Re: 2017-01108_971 Congress

**A101**

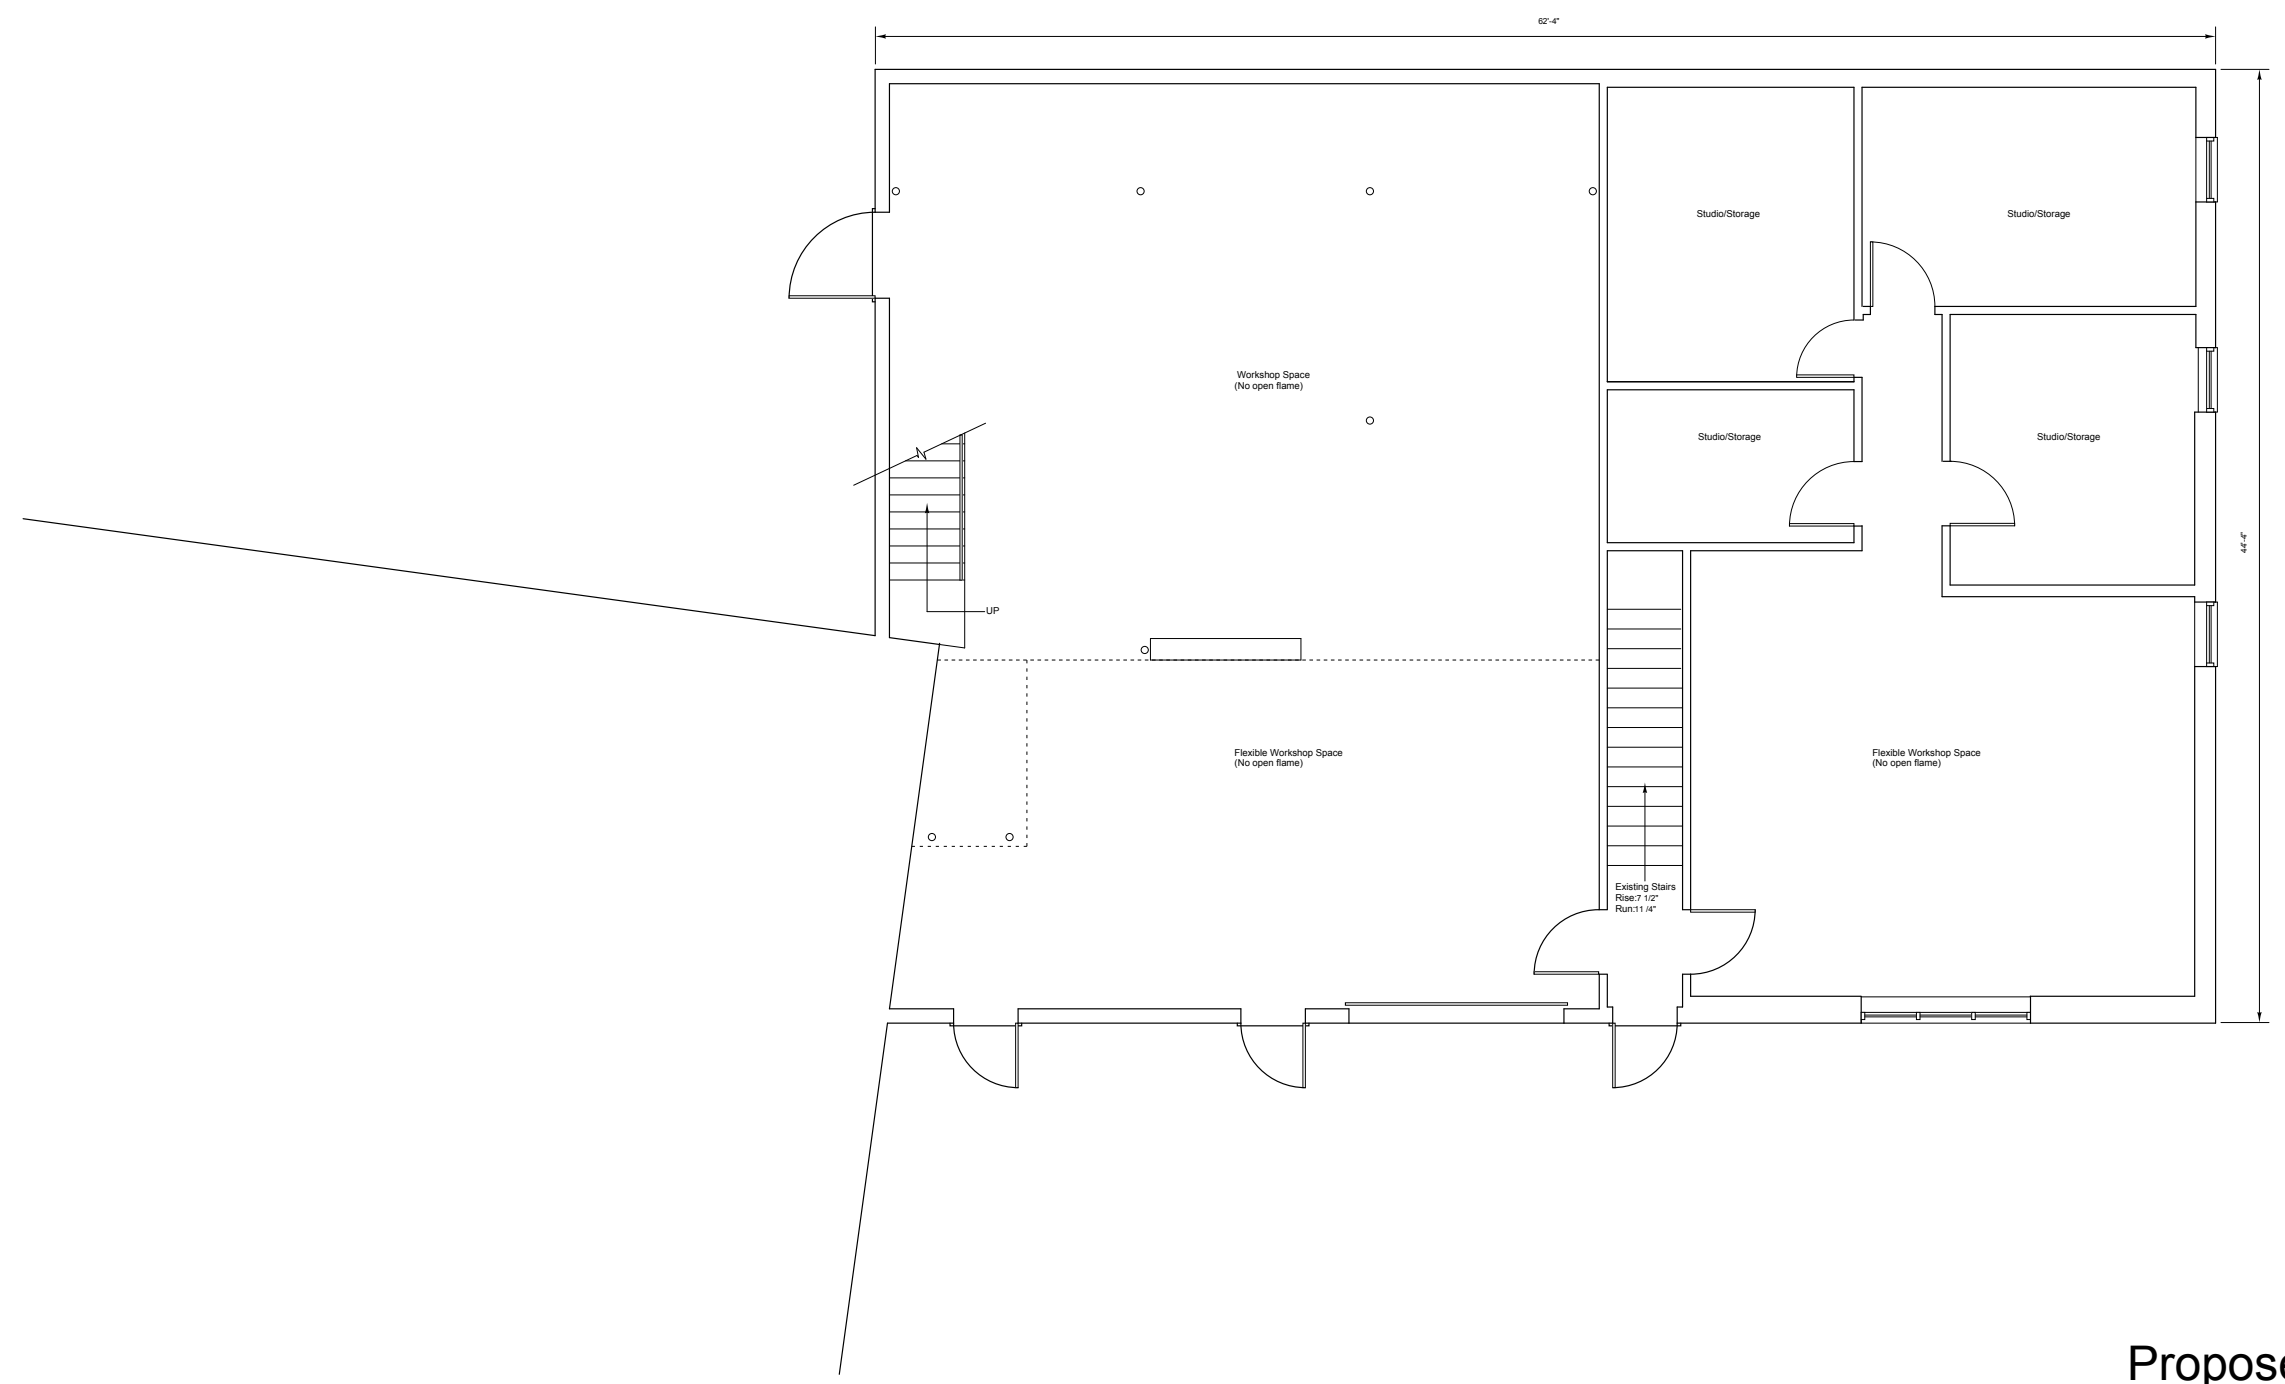
1. Is there a reason the rooms upstairs are not specified to be no open flame like the first floor? As the upstairs is not intended general shop space

I did not think to add these notes. However, I am attaching updated files:

each containing a new note that "**There shall be no open flames on either floor**" We have had a small forge in the past and wanted to indicate that at this time we do not intend to use this in the new space.

F101

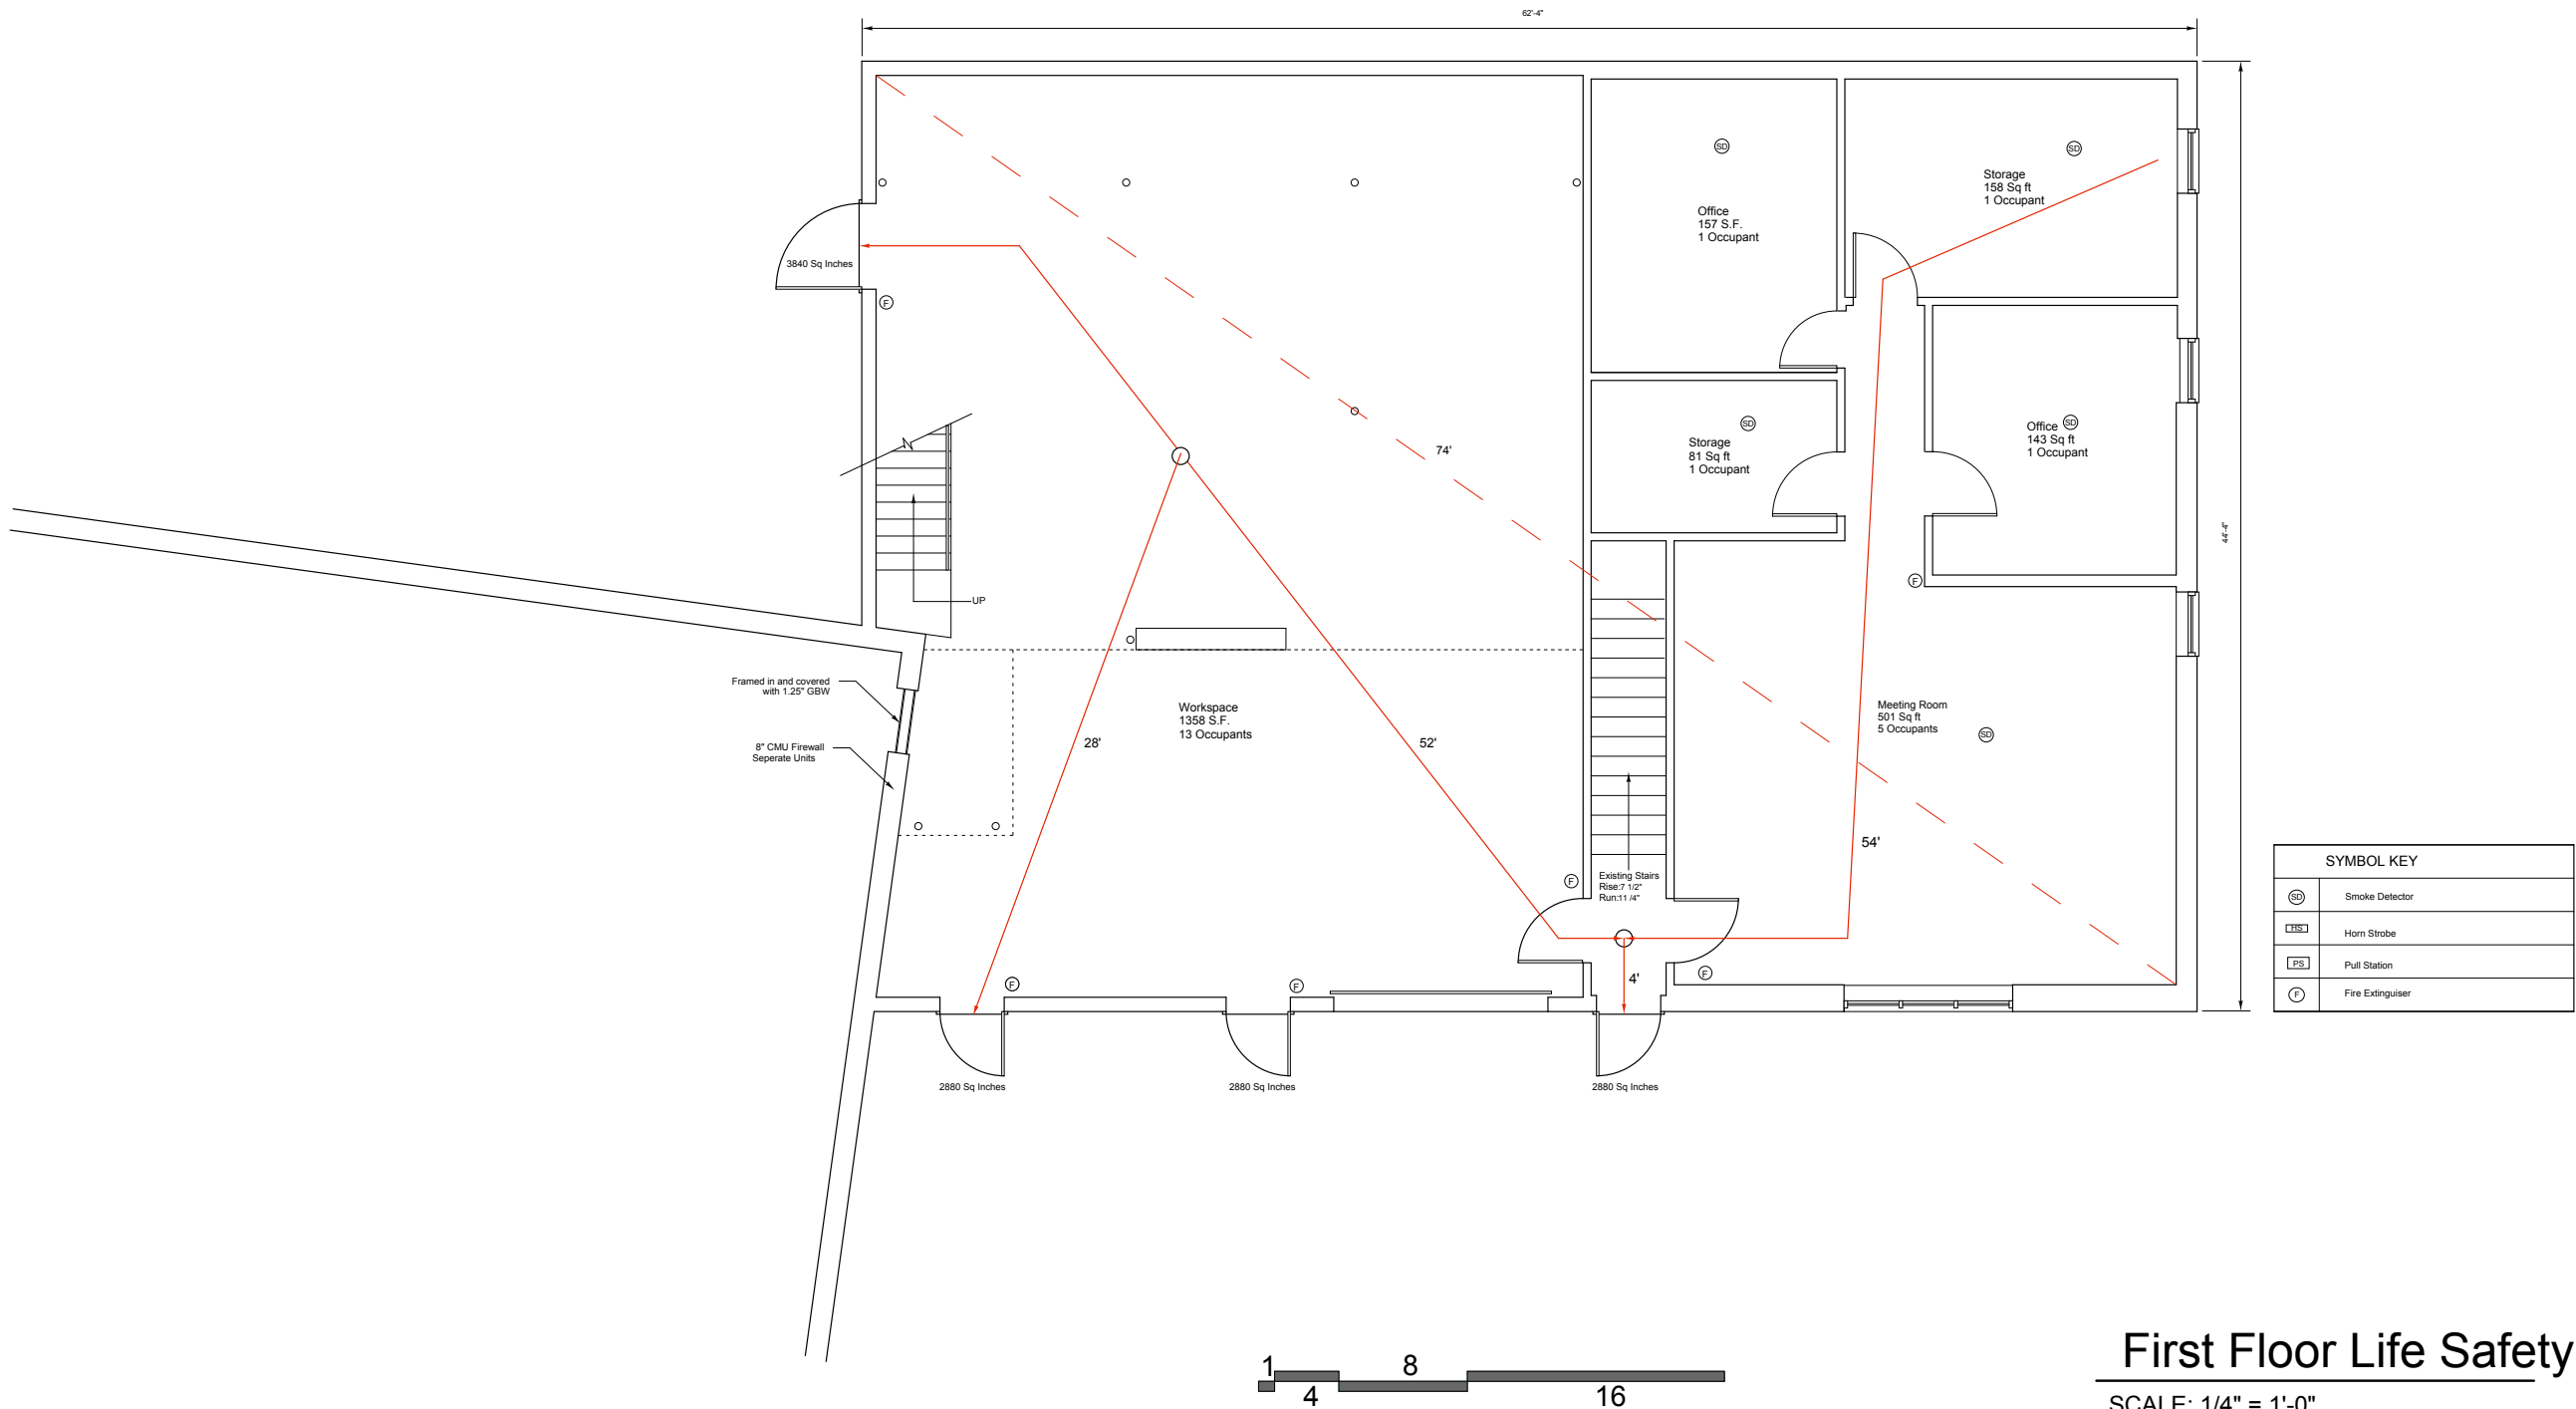
2. You asked for additional information about the connection between this building and the adjacent.
- a. Is it an open connection? **No there is a 2 hr masonry wall separating the spaces** as indicated in the file- F101 First Floor Life Safety .pdf uploaded and sent on Sept 25th.
 - b. Is there a wall? **Yes**, as indicated in the file- F101 First Floor Life Safety .pdf uploaded and sent on Sept 25th.
 - c. Is it a 2 hour fire wall? **Yes**, as indicated in the file- F101 First Floor Life Safety .pdf uploaded and sent on Sept 25th.
